Application for Removal or Variation of a Condition following Grant of Planning Permission or Listed Building Consent

Number	2
Suffix	
Property Name	
Address Line 1	College Drive
Address Line 2	
Address Line 3	Hillingdon
Town/city	Ruislip
Postcode	HA4 8SB

Erection of a single storey extension to the side, erection of a single storey extension to the rear, following the demolition of existing single storey side extension and garage. Installation of 4 front roof lights and amendments to fenestrations including removal of pebble dash and the installation of an Air Source Heat Pump.

79068/APP/2024/2610

DRAWING
PROPOSED ELEVATIONS

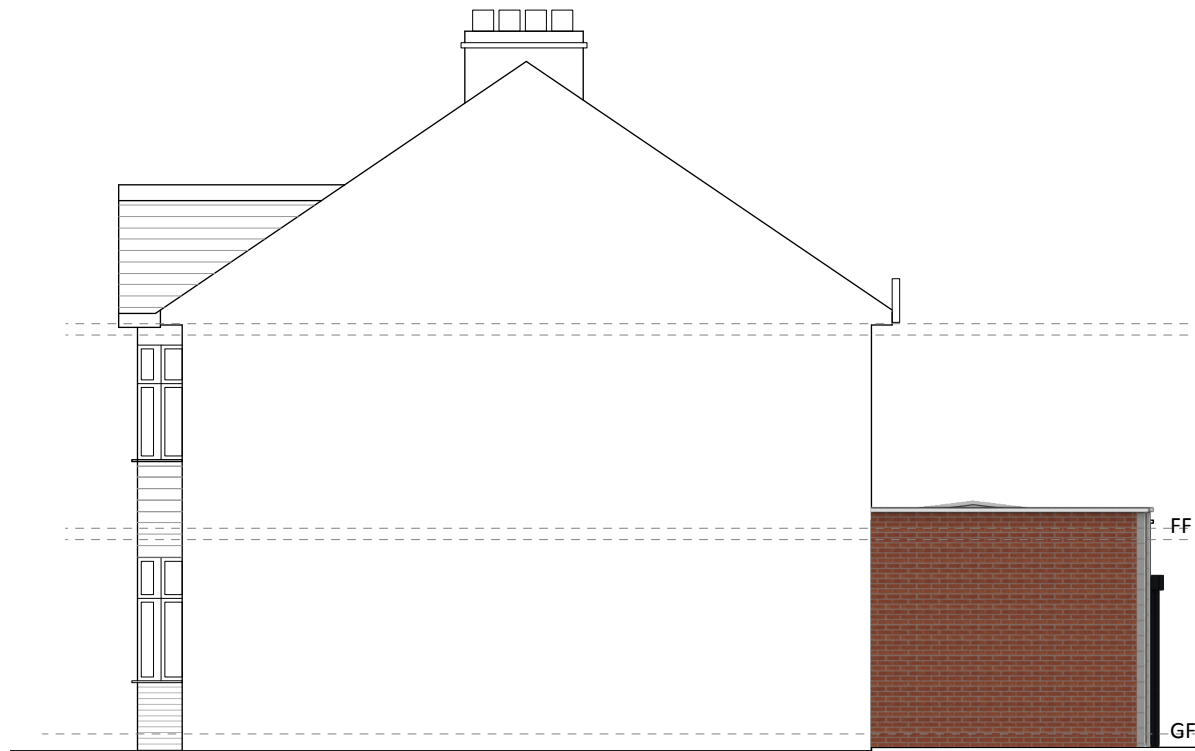
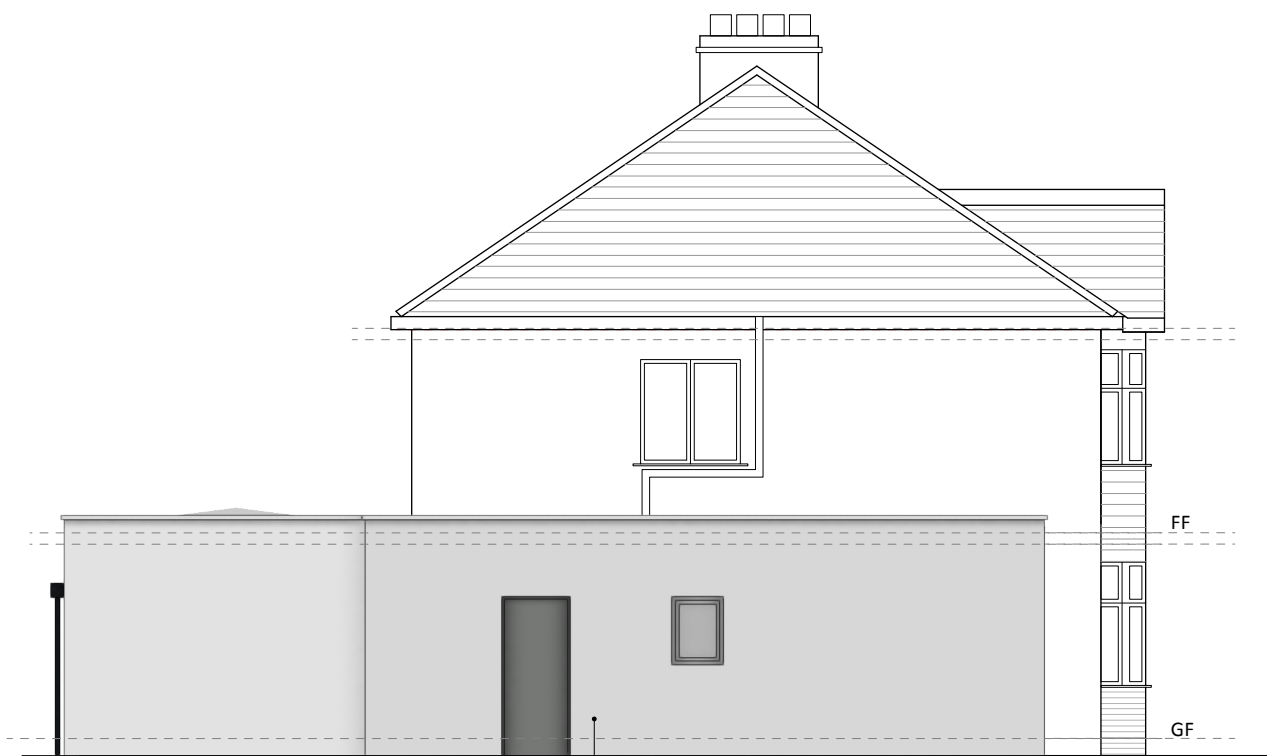
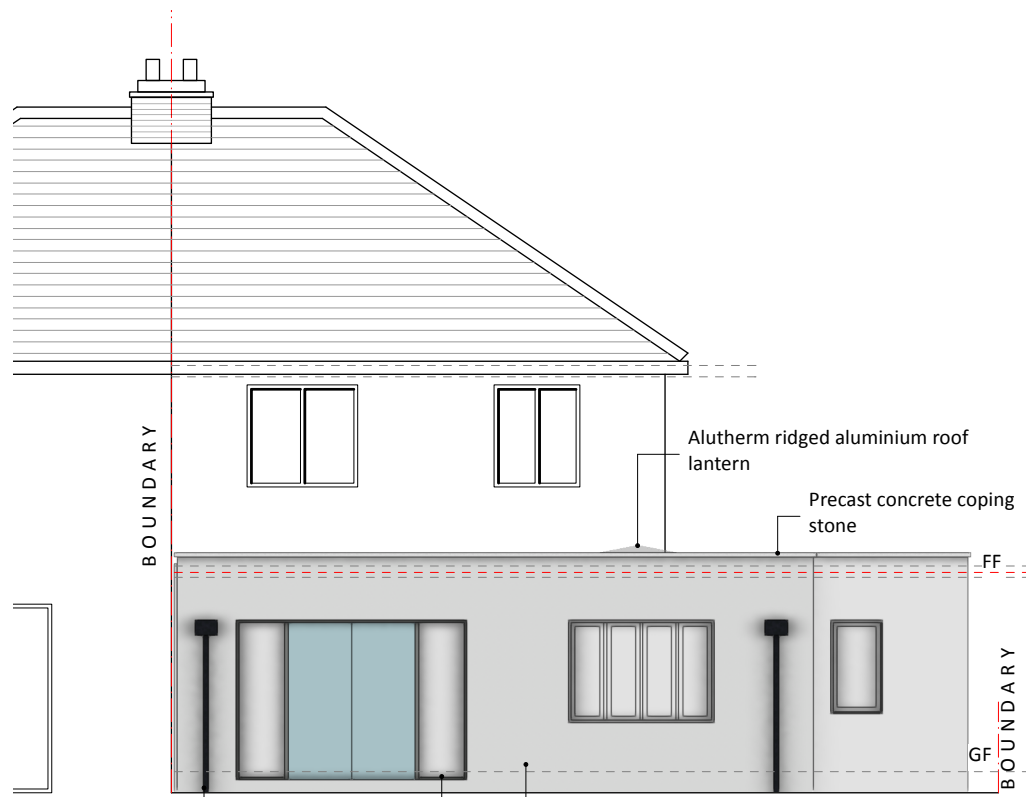
Condition 3 is to be amended so that the front extension elevation remains brick, with the side and rear elevations to be silicone render with stipple finish to match existing traditional render
